EAST SEATTLE / BOYS & GIRLS CLUB PROPERTY vs COVAL PROPERTY (SUMMERWELL) vs

EAST SEATTLE / BOYS & GIRLS CLUB PROPERTY

Builders asking for 14 houses on 2.88 acres – Granted ?????

3/1/19
 JOB NUMBER:
13-118
 SHEET NAME:
SP-01
 SHT **3** OF **9**

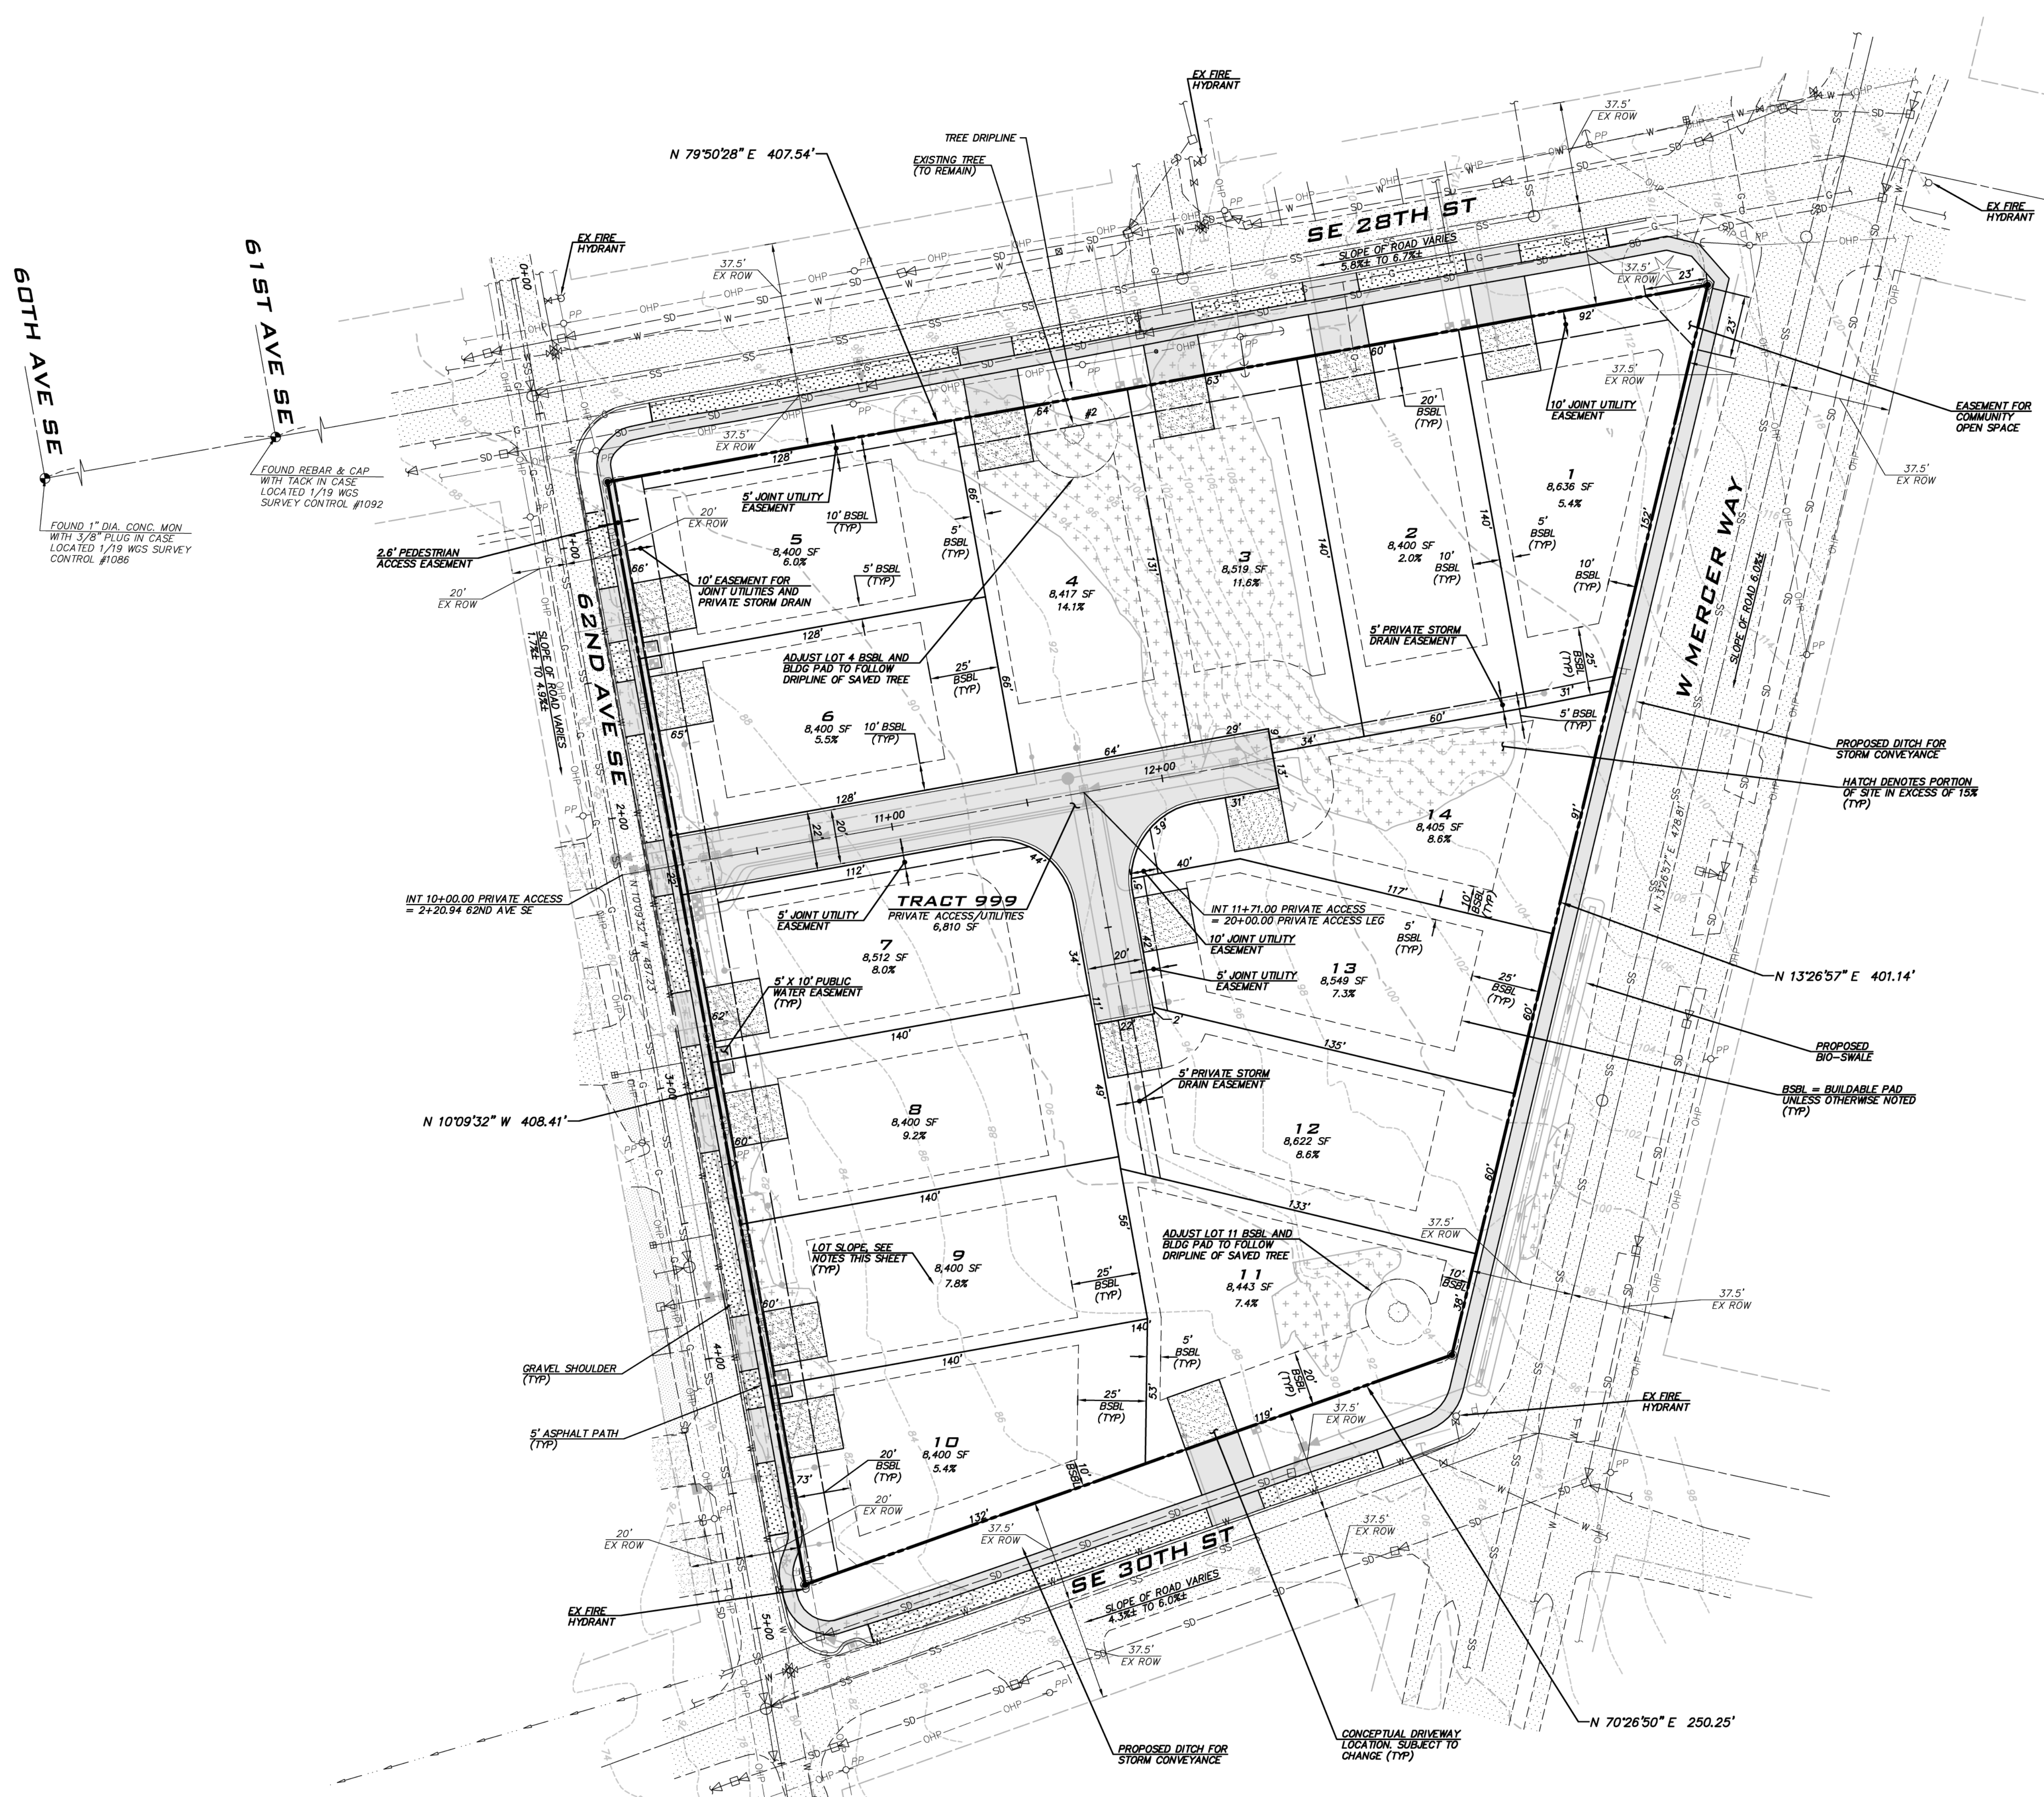
- Are there Sidewalks in development and along West Mercer Way
- Where are water retention ponds on each property (like we were required to put in at our home across the street from this project)
- Builders asking for 52% impervious services; Is the maximum usually 40%
- Is green triangle in upper right hand corner the only public open space.
- Is this where Owner says he will make a “valuable financial contribution” because he has” offered to provide a portion of the property to be improved with informational signage regarding... {East Seattle School’s history}” Instead of declaring it an Historic Building

- Not enough designated Parking – do all houses have a minimum of 2 car garages? Where do lots 12-14 park? Where do visitors and service people to all the homes park? Homeowners extra cars?

- More plants, green space to blend development into neighborhood. But plant dwarf varieties of trees not 100” evergreens that block people’s views
- Too many houses – Coval property development asked for 18 houses on 5 acres and were granted 16. These builders want 14 on 2.88 acres!

SHEET NAME:
RS-01

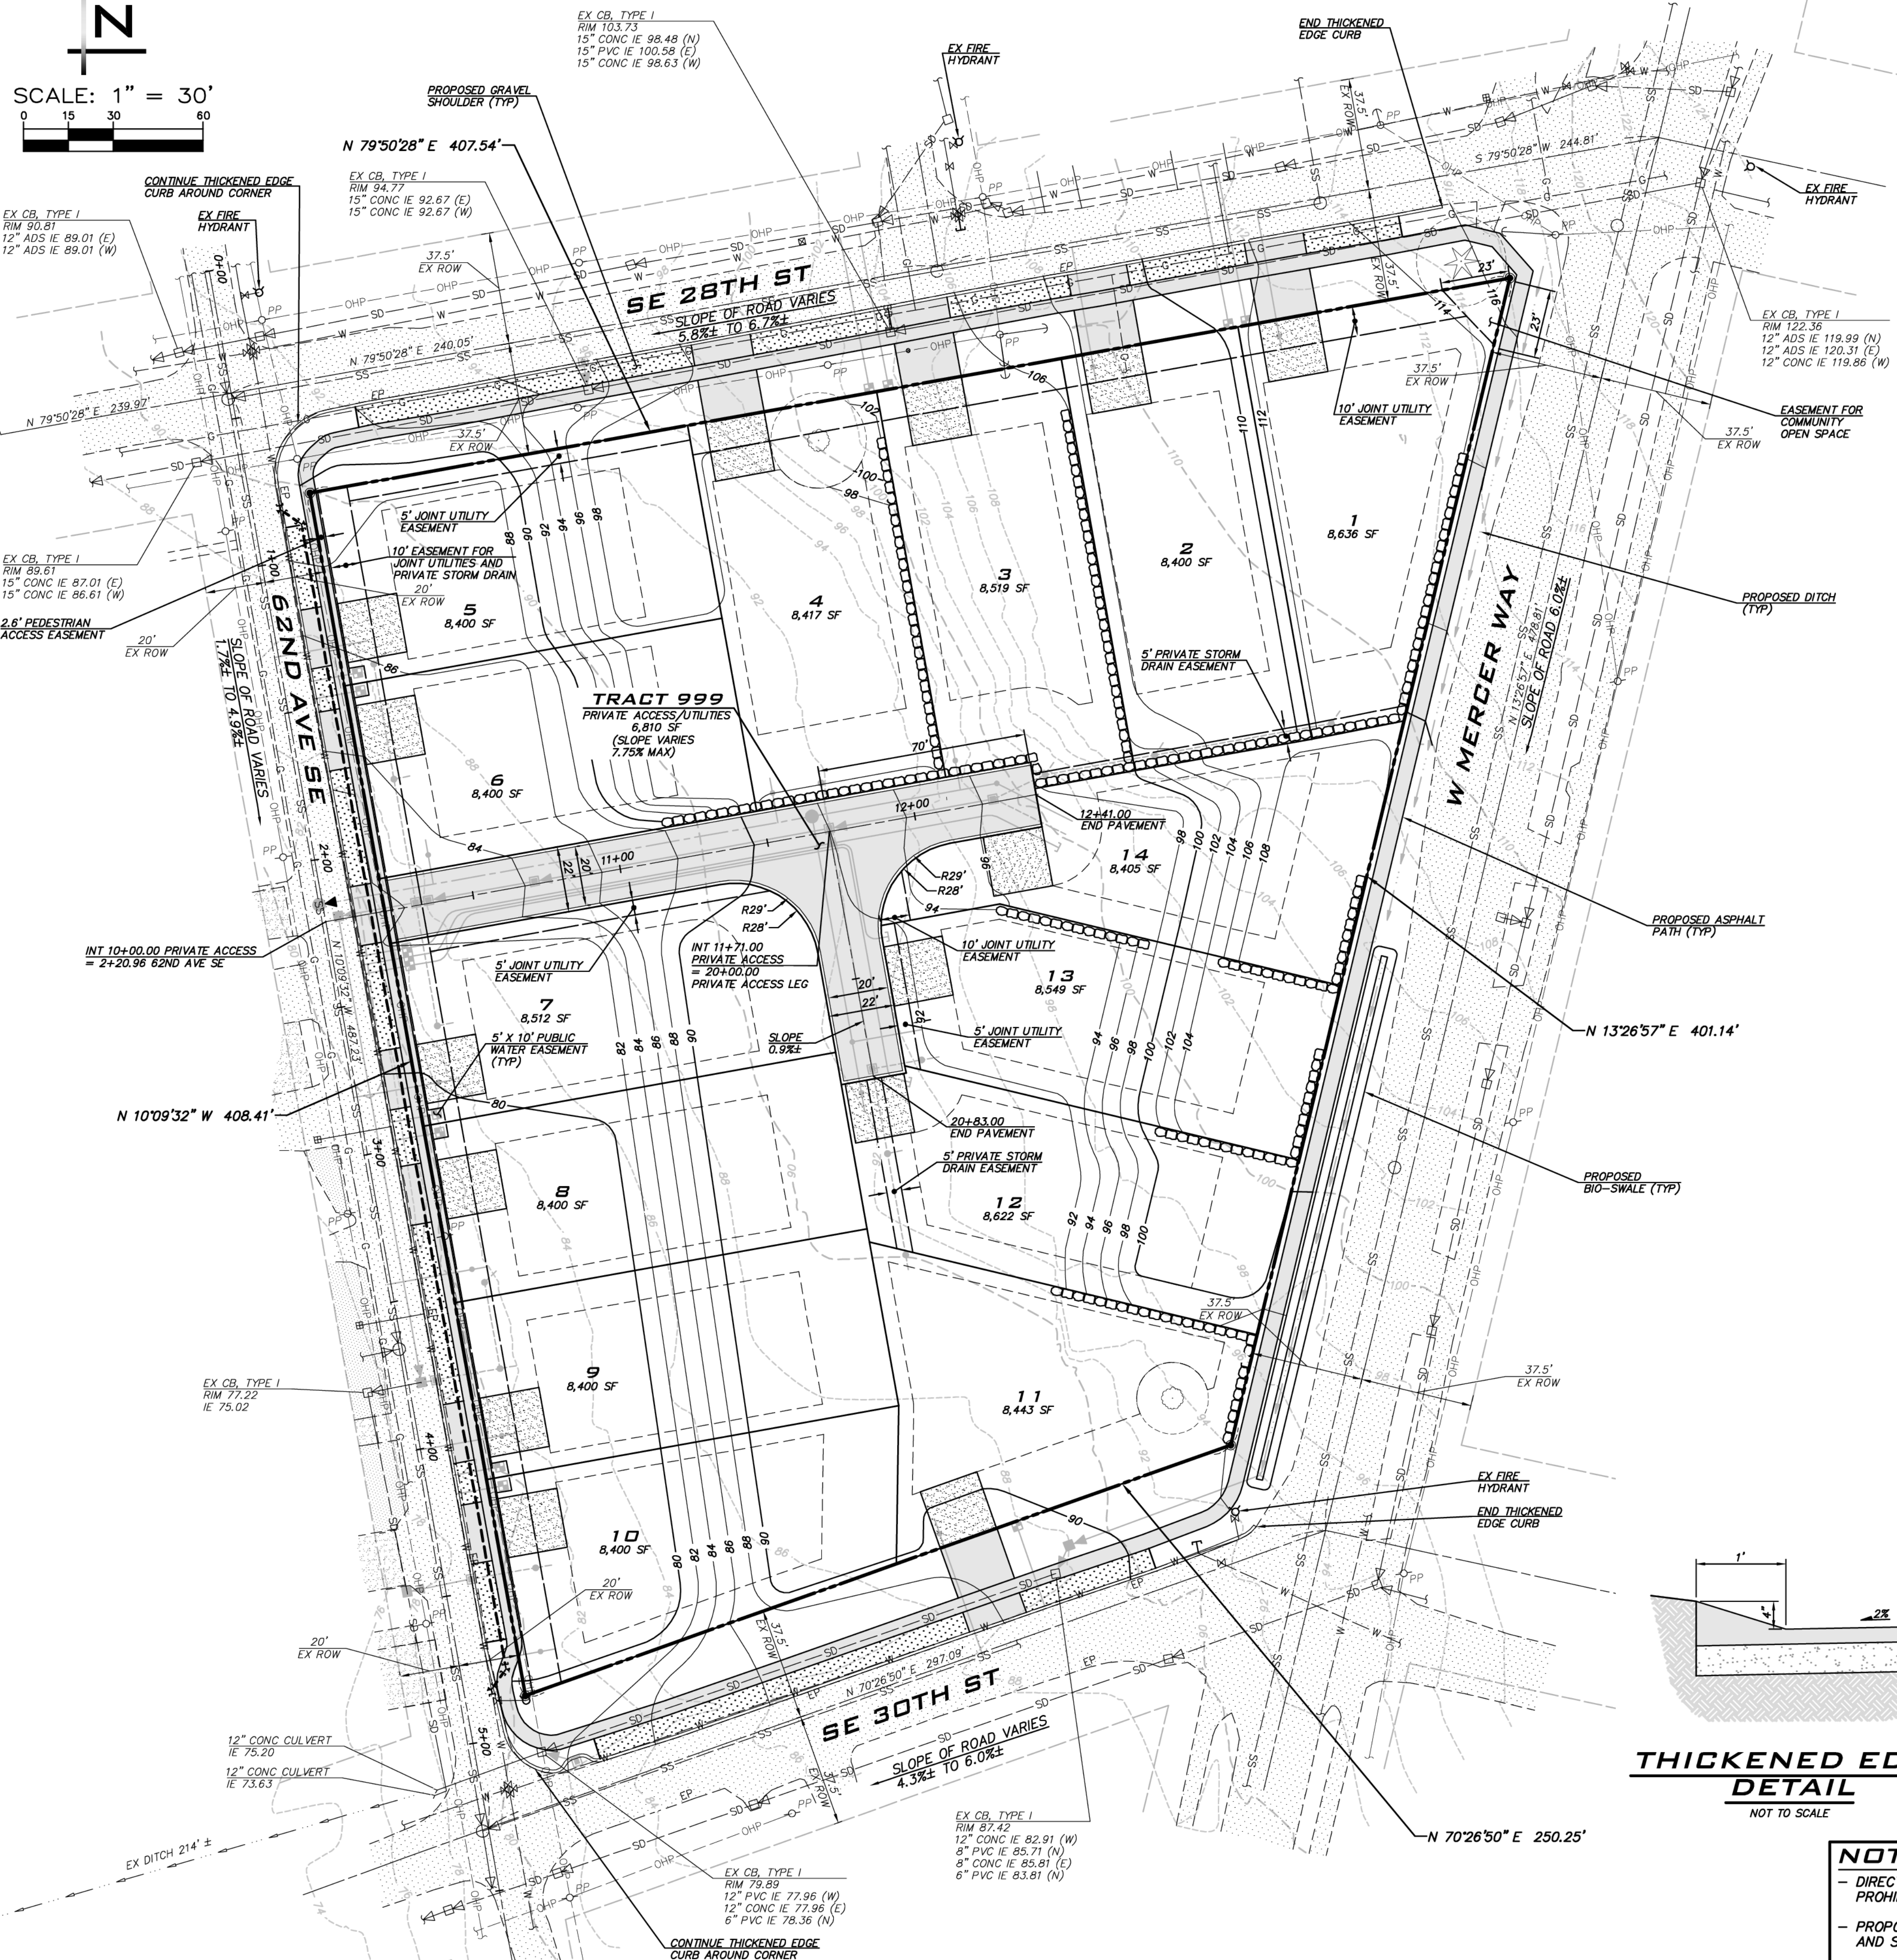
- Access to lots, Public and Emergency Vehicles – In the Public Notice of application I received 4/8/19 the description of request said the” lots would be accessed via a private street connecting to 62nd Ave SE”. I see a narrow street with access to lots 12-14 otherwise each house is accessed from existing streets.
